Item No. **Report of the Head of Planning, Transportation and Regeneration**

Address THE BROADWAY 47 JOEL STREET EASTCOTE

Development: Erection of a four storey building to create two business units and 1 x 2-bed residential unit involving demolition of existing store/garage to rear and remodelling of existing basement to increase business use

LBH Ref Nos: **17155/APP/2020/3664**

DRAWING TITLE
LOWER GROUND & GROUND FLOOR
PLANS (GROUND AND FIRST AT
FERNDOWN) PROPOSED

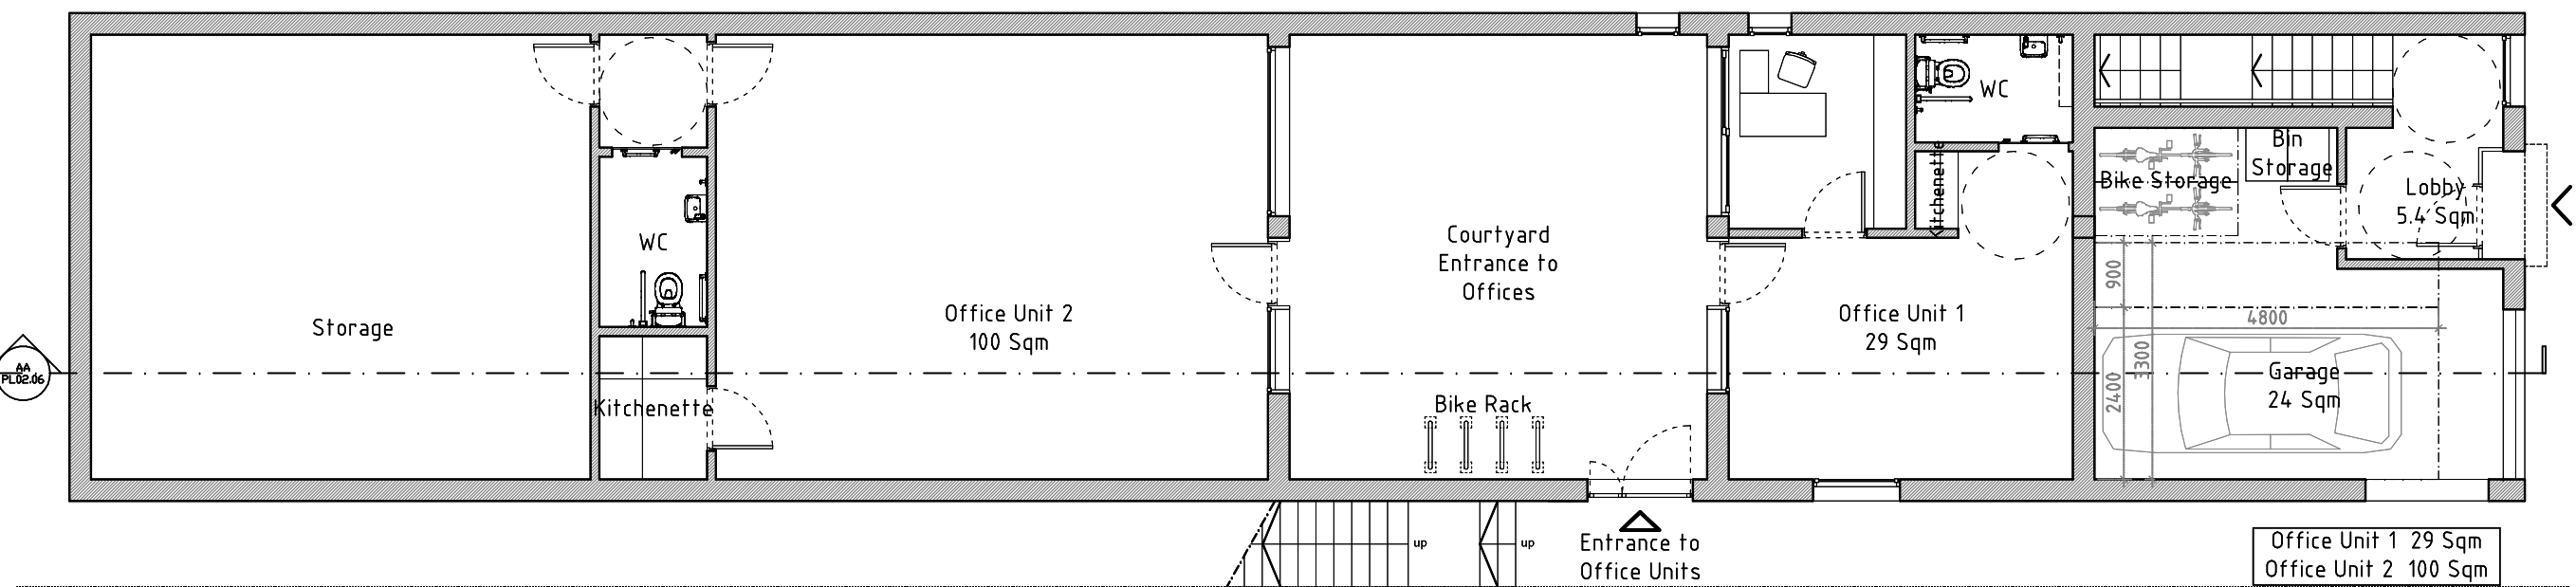
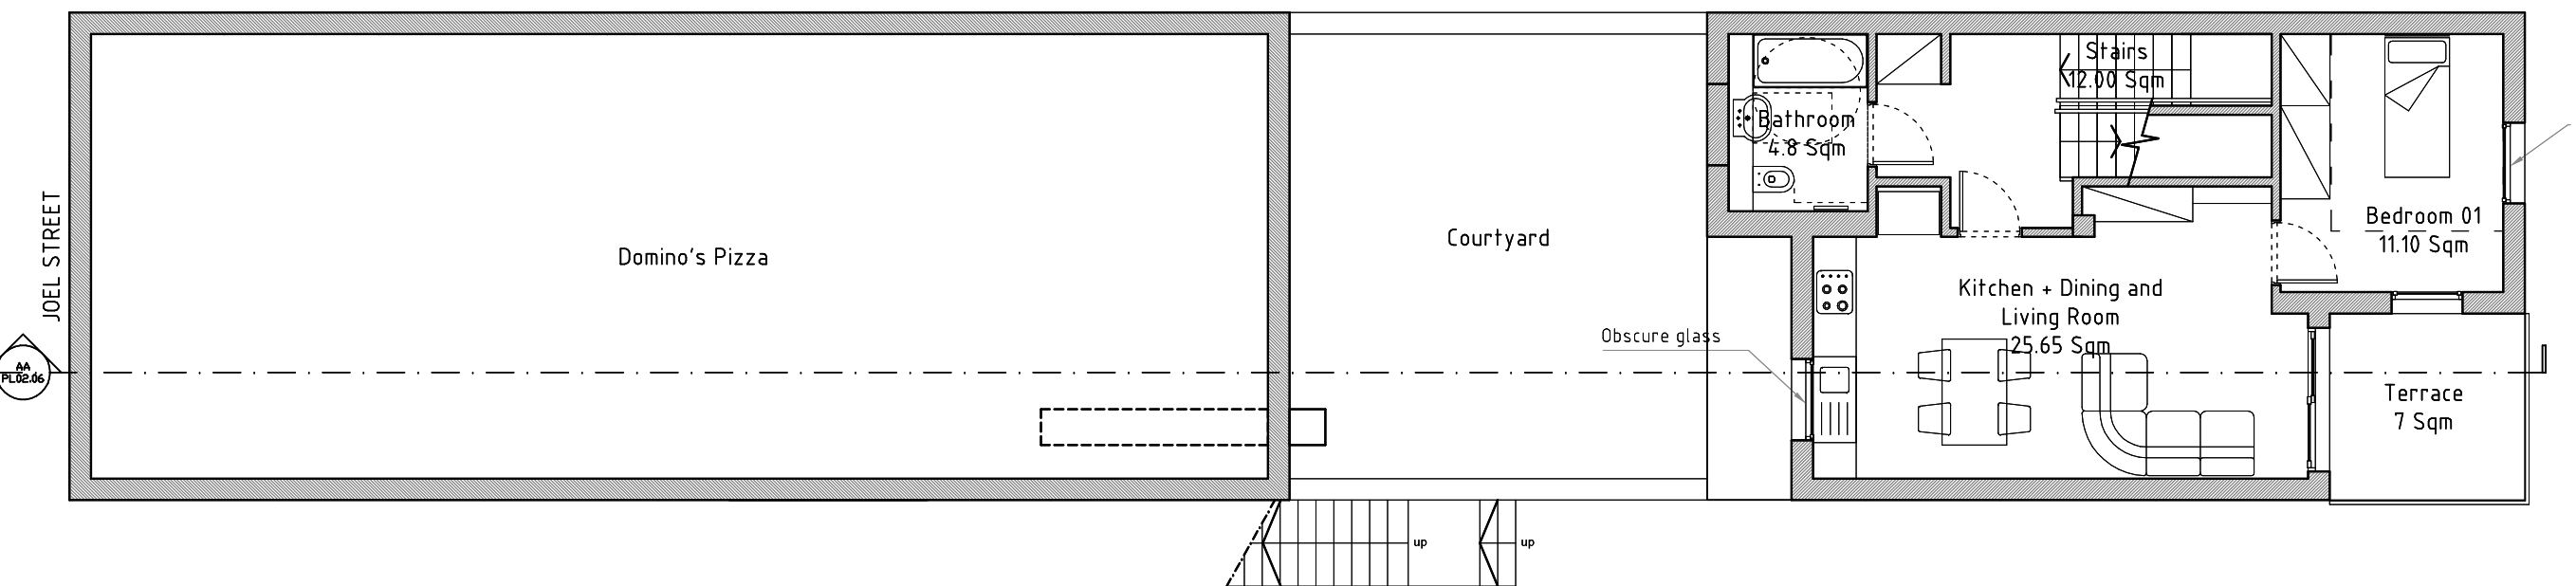
An assessment of this proposal has been conducted with reference to policy 3.1 (Ensuring equal life chances for all), 3.8 (Housing choice) and 7.2 (An inclusive environment) of the 2016 London Plan. The proposed new building at ground floor would be accessed via a series of steps as shown on drawing number PL 02.03 B, leading from a terrace. The intended office accommodation and housing on the floors above ground would also be accessed via a staircase, and a lift is not proposed: 1. In accordance with London Plan policy 7.2, wheelchair access into the proposed new commercial space on the lower ground and ground floors is a requirement, as the building would be a new facility. The stepped arrangement as shown on plan is unacceptable. 2. All new housing should be accessible and adaptable in accordance with policy 3.8 (c). It is noted however, that it may not be feasible to provide wheelchair access to the residential element. This would be supported by paragraph 3.48A of the London Plan (March 2016) which recognises that the application of M4(2), requiring lift access (a step free approach to the principle private entrance), may have particular implications for developments of four storeys or less where historically the London Plan may not have not required a lift. Local Planning Authorities are therefore required to ensure that dwellings accessed above or below the entrance storey in buildings of four storeys or less have step-free access. Unless the applicant submits a clear, well evidenced and compelling case to the LPA as to why lift access cannot be provided, the application should not be supported on the grounds of non-compliance with the 2016 London Plan policy 3.8(c) and policy D7 of the 2019 (Intend to Publish) London Plan. Conclusion: unacceptable.

The Access Officer has advised that In accordance with London Plan policy 7.2, wheelchair access into the proposed new commercial space on the lower ground and ground floors is a requirement, as the building would be a new facility. The stepped arrangement as shown on plan is unacceptable. In addition all new housing should be accessible and adaptable in accordance with policy D7. Whilst noting it may not be feasible to provide wheelchair access to the residential element, the applicant has failed to provide any evidenced or compelling case to the LPA as to why lift access cannot be provided. Therefore the application fails to comply with policies D5 and D7 of the 2021 London Plan.

DATE	DRAWING NO.	REVISION
05.10.2020		
SCALE		
1/100 @ A3	PL 02.06	C
ICE JOB NO.		
19.24.7		
CAD FILE NAME		
ICE19.24.7.PL.PRO.REV@	Copyright ICE ARCHITECTS LTD. 2021

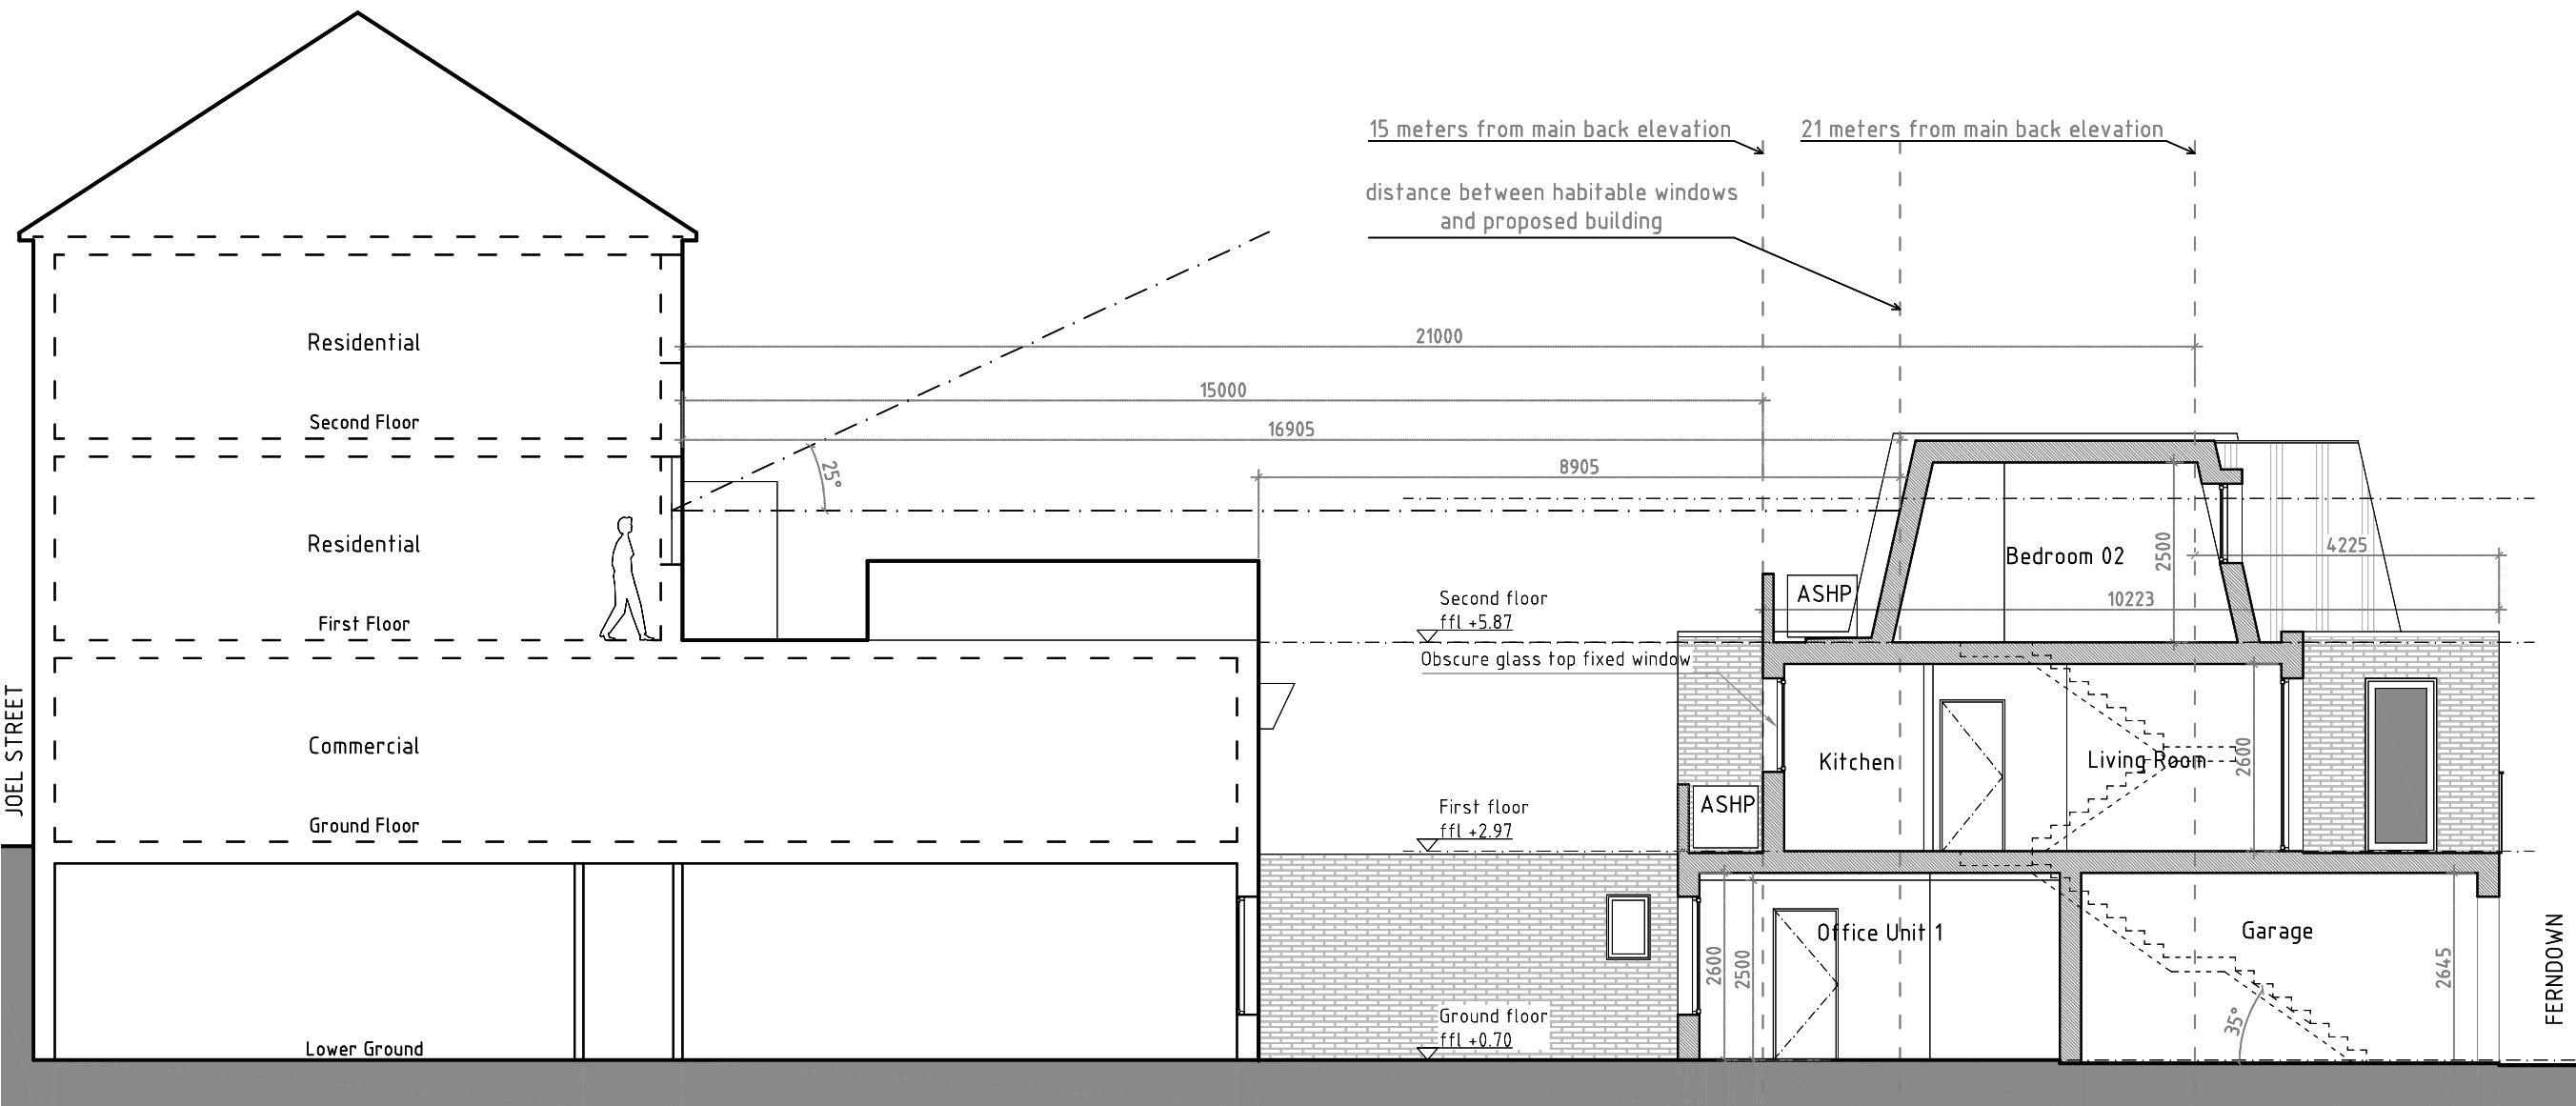
The proposed projecting staircase of the 4 storey building would be set back approximately 14.1m from the rear of no 47, with the main body of the building approximately 15m away. This would have a height of approximately 4.7m and would be approximately 6.05m from the terrace, which forms the amenity space for the occupiers of the existing residential unit. The neighbouring property at no. 49 currently benefits from a rear extension, with two large habitable room windows. The proposal would be situated approximately 7.5m from the rear of that property within a 45 degree line of sight, which

The proposal includes a high level window serving a kitchen on its rear elevation facing the Joel Street properties. The principle windows serving the bedrooms and living room and the terrace area fronting Ferndown. It is noted that the submitted site plan is not up to date and does not accurately show the property at no. 27 Ferndown. Although this dwelling is set an angle to the site and there would be no direct overlooking between habitable rooms, it would overlook the garden area and rear private patio at a distance of less than 21m. As such it is considered that the proposal would result in a loss of privacy to the neighbouring occupiers.

The proposed building would comprise a 4 storey mixed use block at a height of approximately 11.65m. It has a maximum width of 6.8m and depth of 11.15m. This would be set immediately adjacent to the road. This is a substantial building in a very prominent position, which would be an incongruous addition which would be unduly overly dominant and out of scale with the character and appearance of the area.
